NUEVO ATRISCO | MAJOR SITE PLAN AMENDMENT DRB COMMENT RESPONSES

NUEVO ATRISCO DRB Comment 6.24.2022 Responses					
Commenting Agency	Action	Date Received	Comment	Applicant Response	Applicable sheets
NMDOT	PR-2018-001405 Site Plan PR-2020-003847 Plat	6.24.2022	NMDOT does not have any comments at this time	No response necessary	-
AMAFCA	PR-2020-003847 Plat	6.24.2022	No adverse comments	No response necessary	-
MRMPO	PR-2018-001405 Site Plan	6.24.2022	MRMPO has no adverse comments	No response necessary	-
	PR-2020-003847 Plat	6.24.2022	MRMPO has no adverse comments.	No response necessary	-
ABCWUA	PR-2018-001405 Site Plan	6.24.2022	Availability Statement #211219 has been issued and provides the conditions for service. The availability statement indicated a fire flow of 1,725 gpm whereas the provided fire one plan in the DRB submittal indicated a fire flow of 2,000 gpm. Please confirm. A new request for availability may be required to account for the increase in fire flow.	Civil is coordinating with ABCWUA and has submitted a new water availability statement

PR-2018-001405 Case Description: Amendment to Site Plan | SD-2022-01115, VA-2022-00165 Sidewalk Wavier | PR-2020-003847 Case Descr

DRAWN BY	JD, TC
REVIEWED BY	D/P/S
DATE	06.03.2022
PROJECT NO.	19-0059.002
DRAWING NAME	SITE DEVELOPMENT PLAN
SHEET NO.	SDP1.1

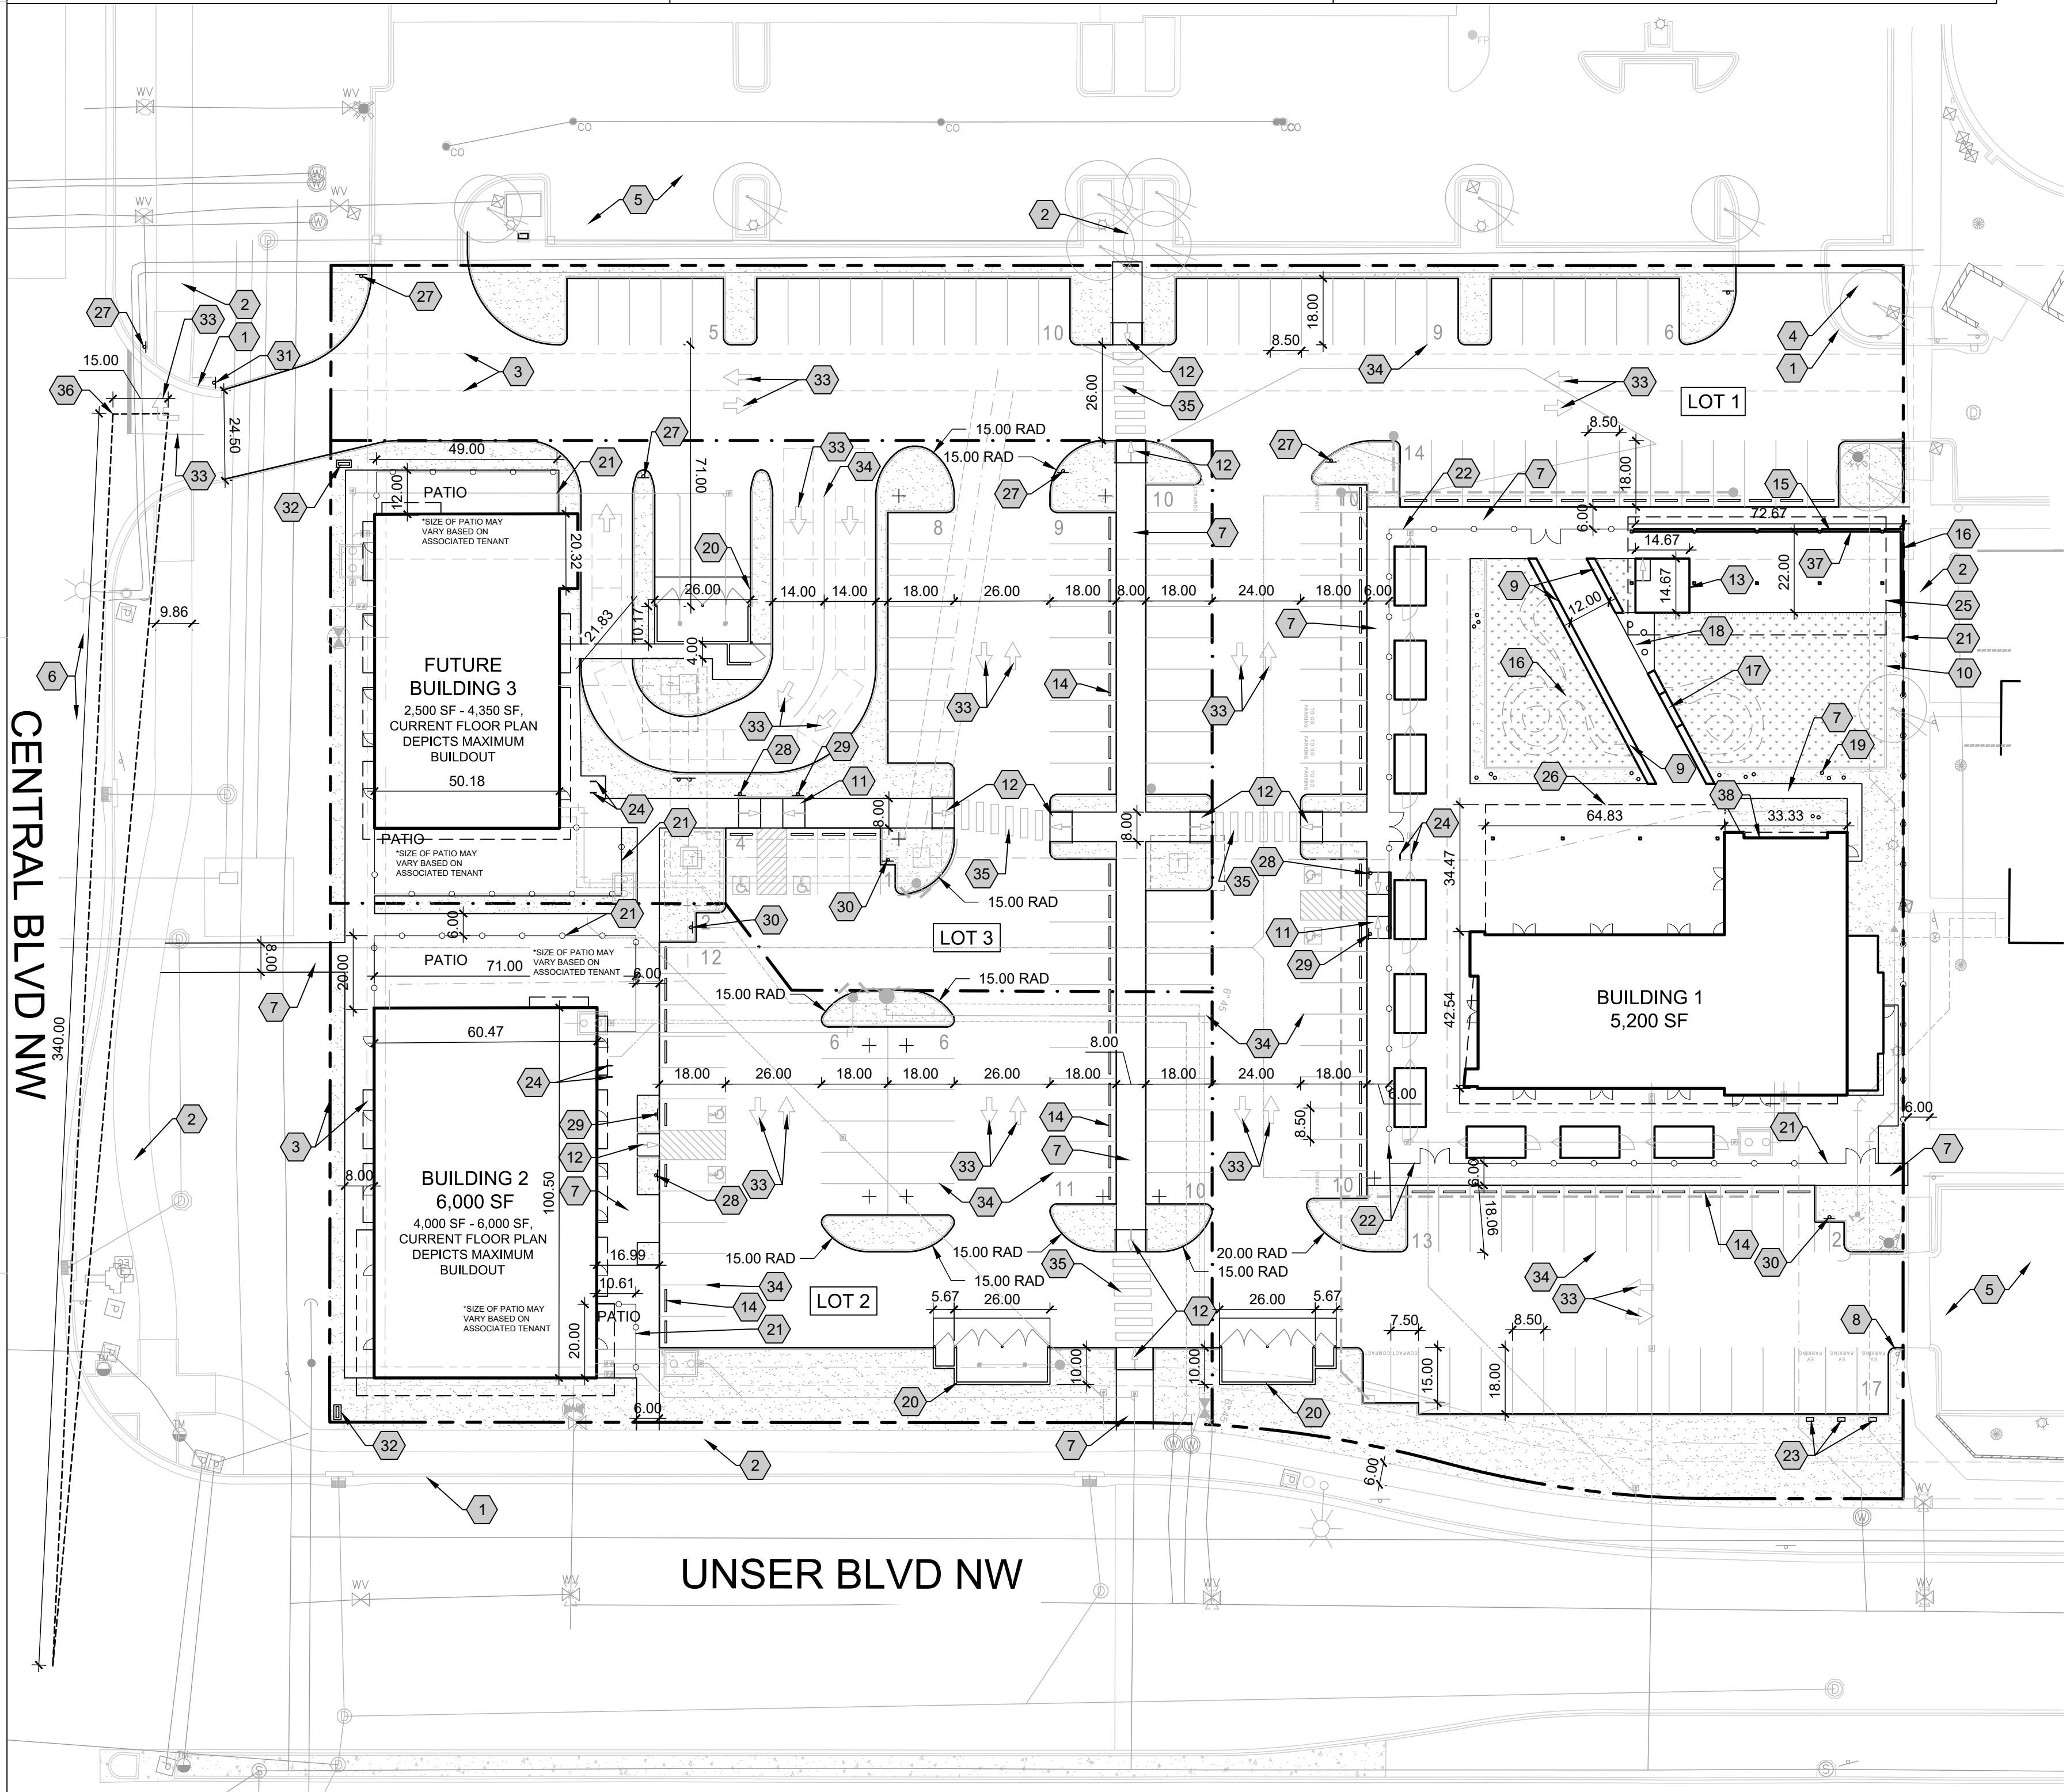
Planning	PR-2018-001405 Site Plan	6.24.2022	Please identify the front (is the front Central Avenue?), side and rear of the buildings and show setback measurements on the Site Plan for compliance with Table 5-1-2.	Yes, Central Avenue is the front, Unser is the side and the property line abutting the apartments is the rear. SDP1.1 was amended to lists required setback in Project Data, identification about front/side/rear was added.	SDP1.1
Planning	PR-2018-001405 Site Plan	6.24.2022	Elevations should show a measurement for the total building height of each building even though it is clear that buildings will comply with 65 foot height allowance for a Premium Transit area.	The elevation sheets SD5.1, 5.2 and 5.3 indicate a T.O. ROOF that shows the total building height measurement.	SDP5.1-5.3
